Re: Objection to MP08_0244 MOD 1 Modification Request for Mixed Used Development at 23-37 Lindfield Avenue and 11 Havilah Lane, Lindfield

As a resident of Lindfield, I/we wish to lodge an objection against the proposed Modification of the subject development based on the following grounds:

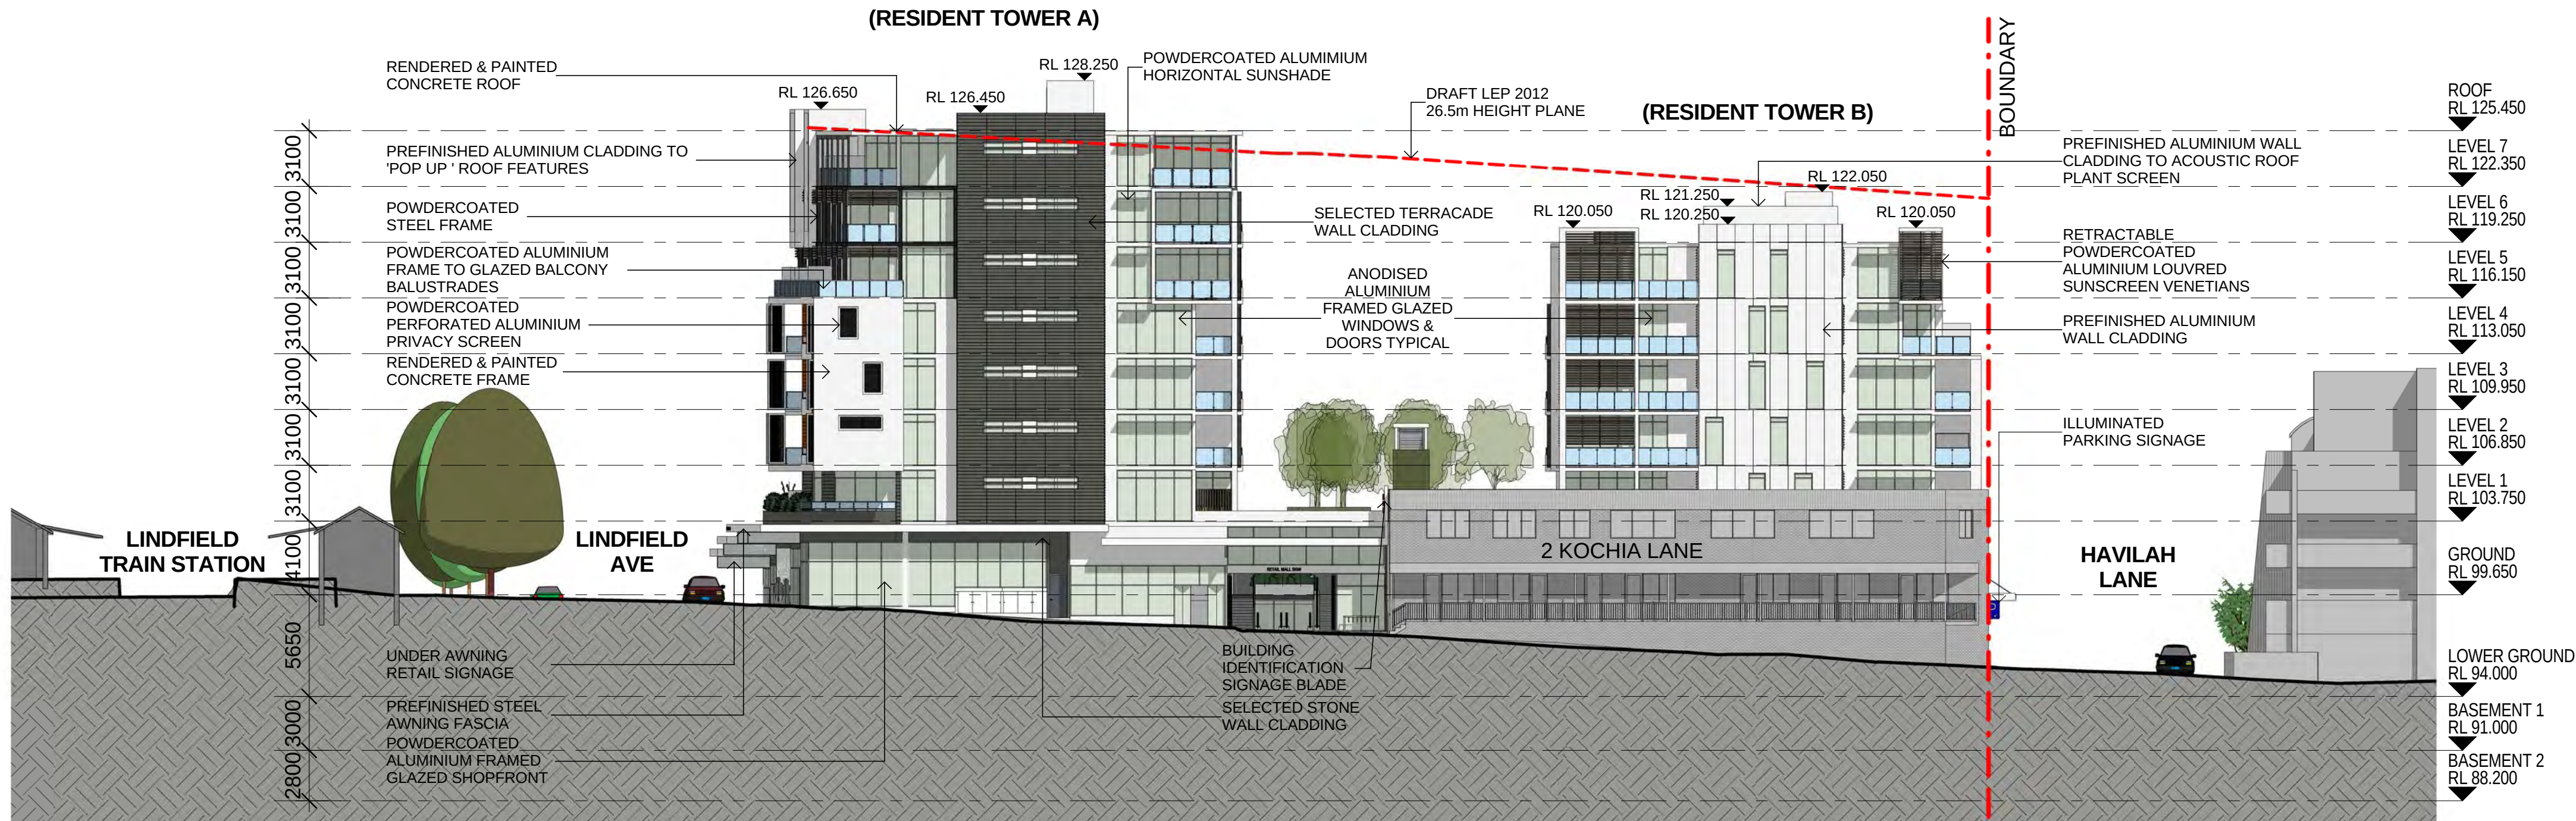
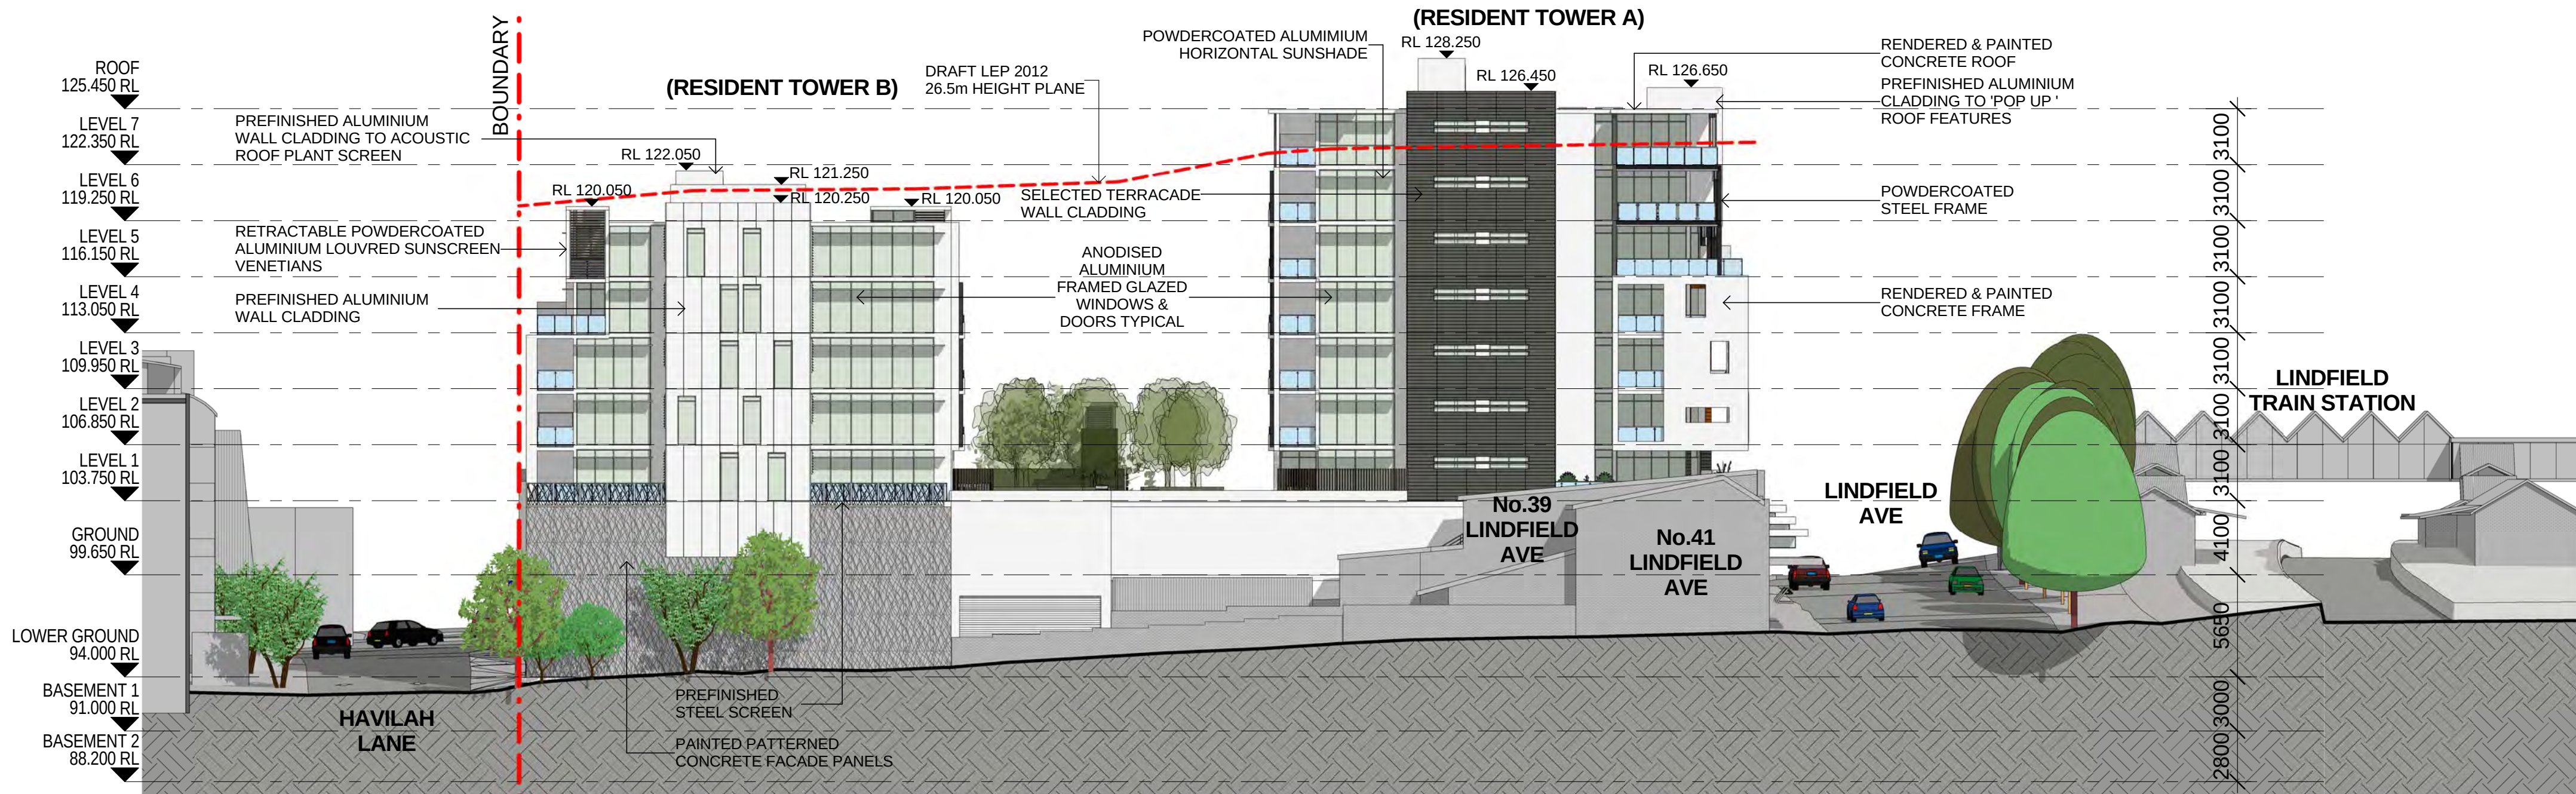
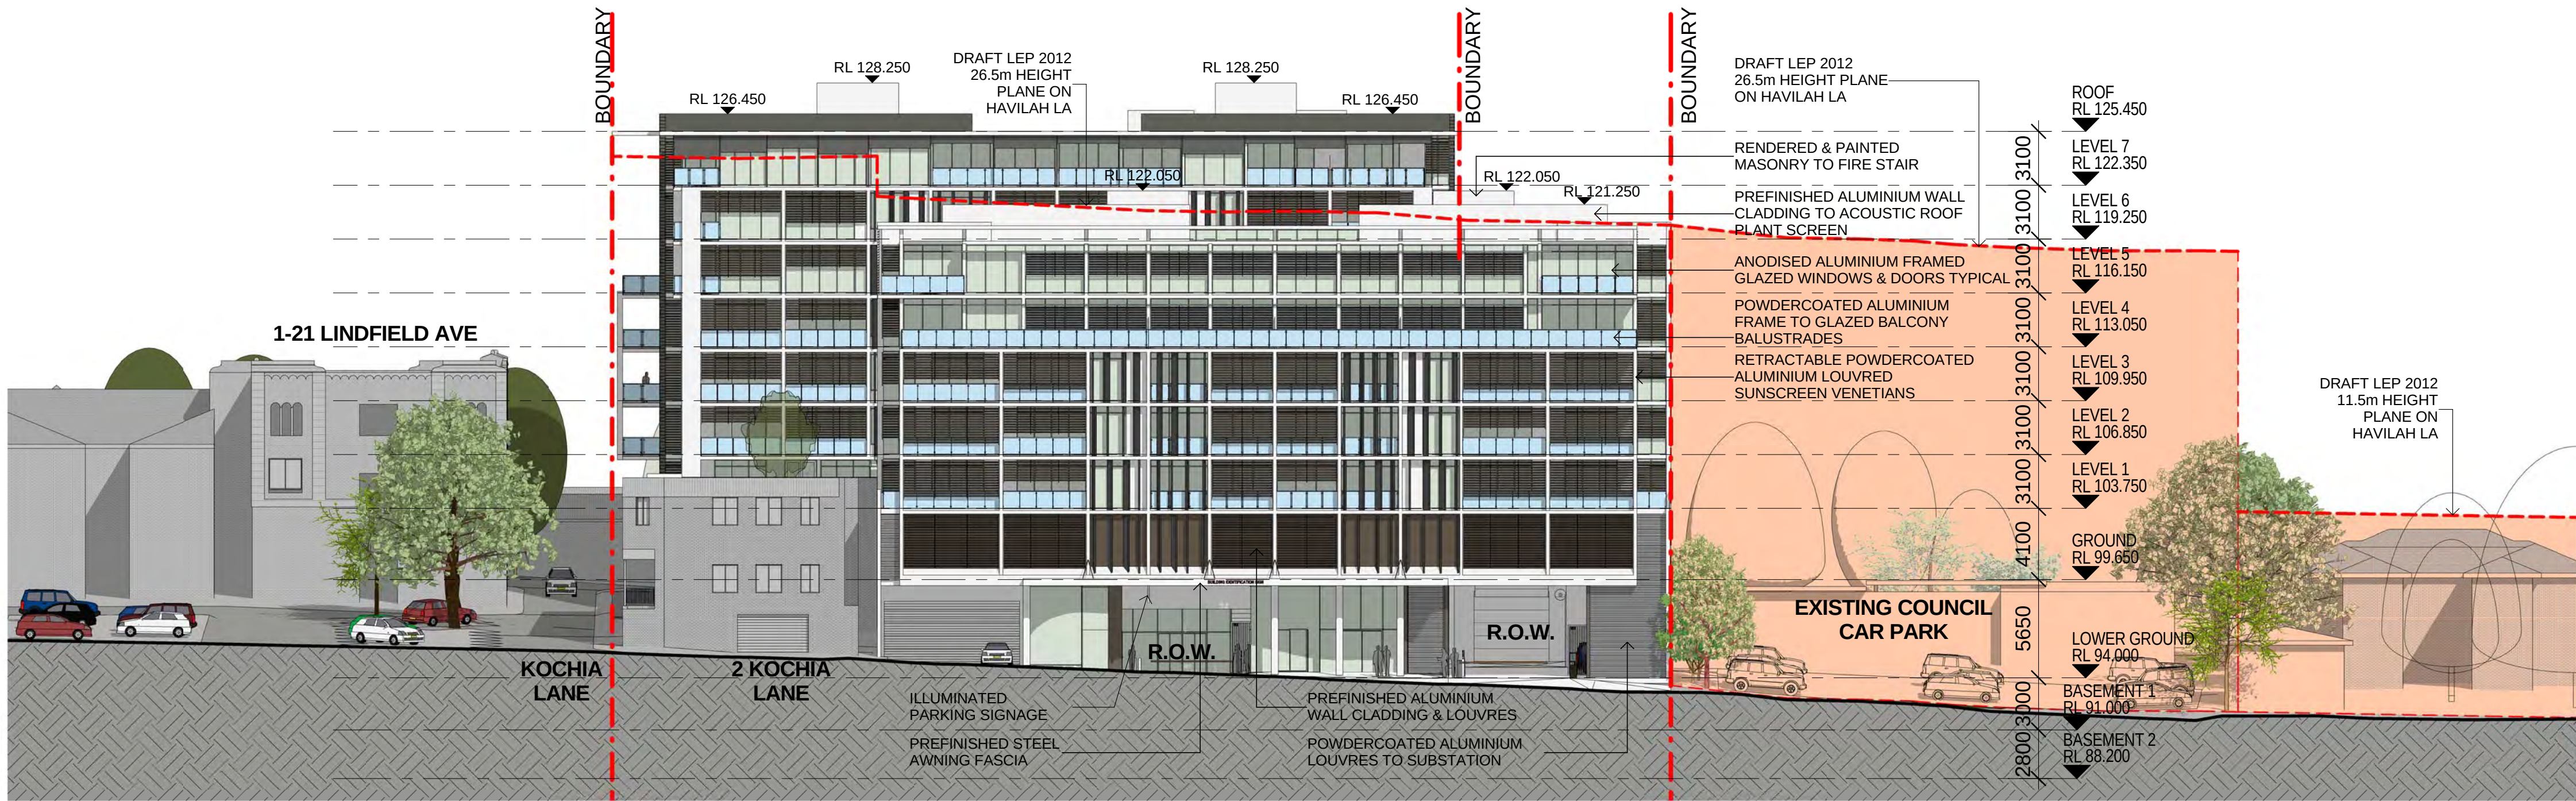
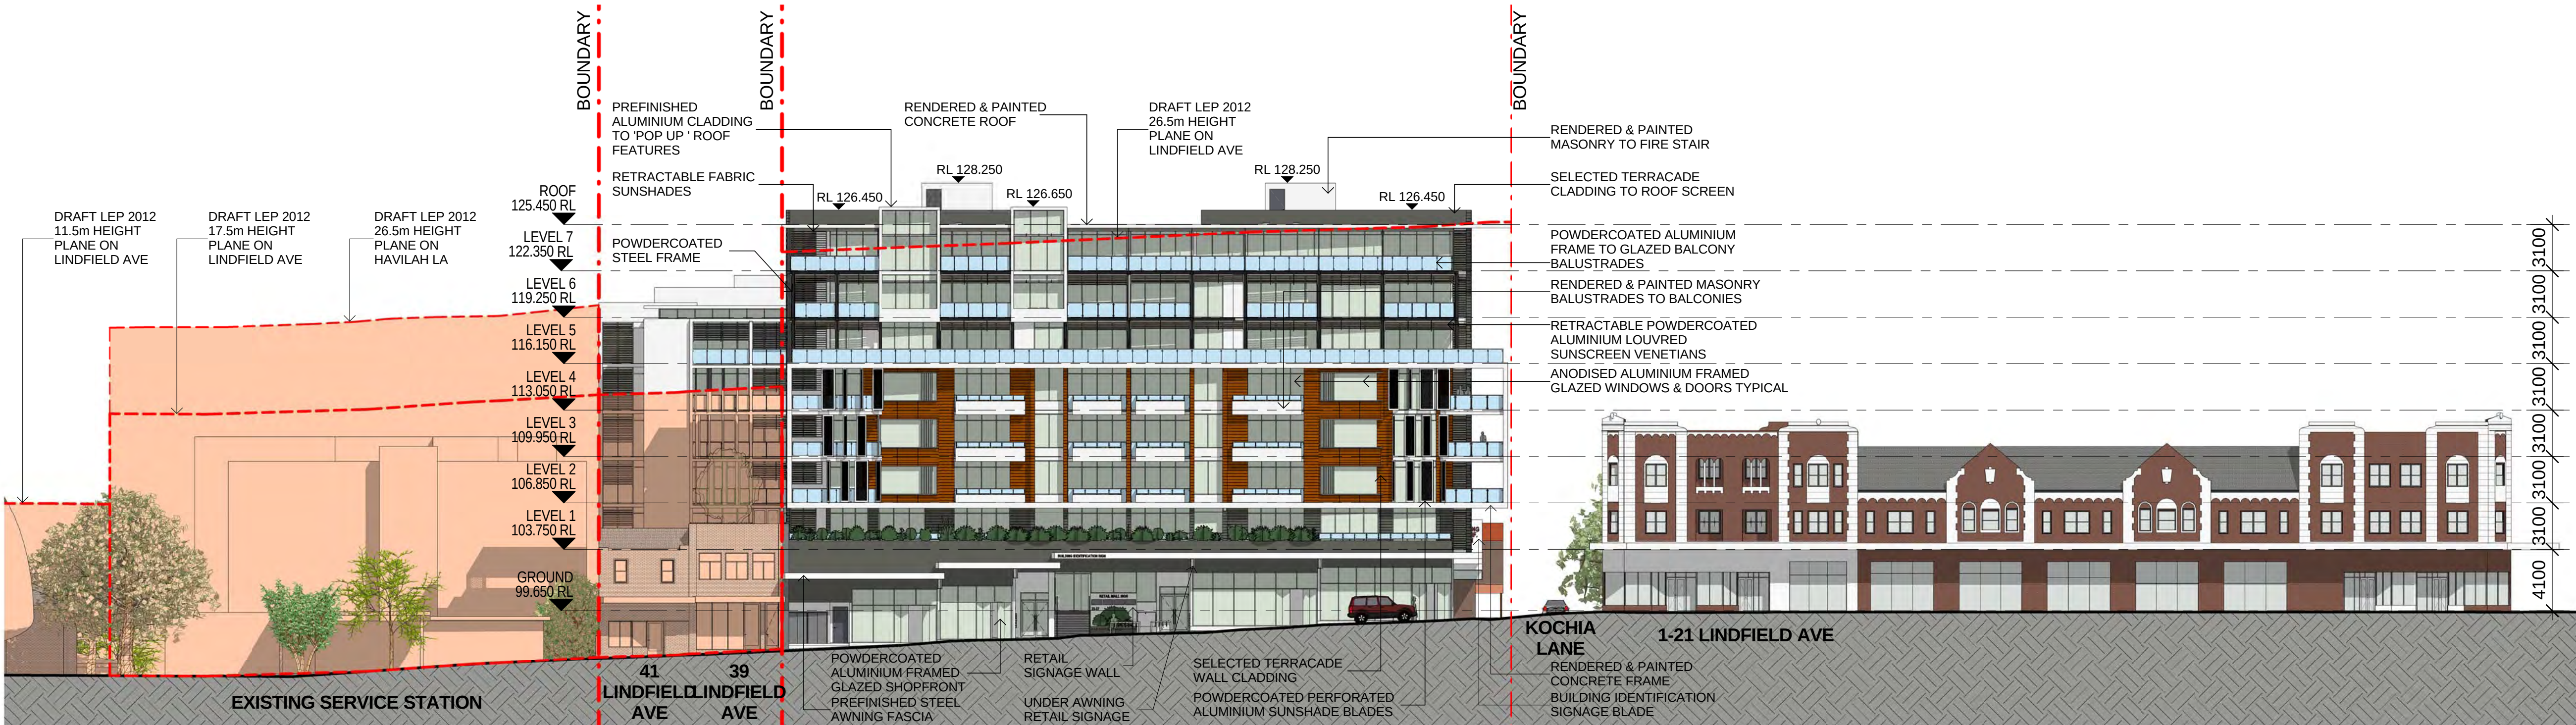
- The increase of an additional storey to both buildings: 8 storeys on Lindfield Avenue and 7 storeys on Havilah Lane creates excessive height and bulk and is out of character with the surrounding buildings, including the heritage listed adjacent building on Lindfield Avenue

- The additional storey (combined with less set back than the approved design) on Havilah Lane now creates privacy concerns for over 40 apartments in the adjacent 8 Havilah Lane, 8 Kochia Lane and 2-8 Milray Street residences
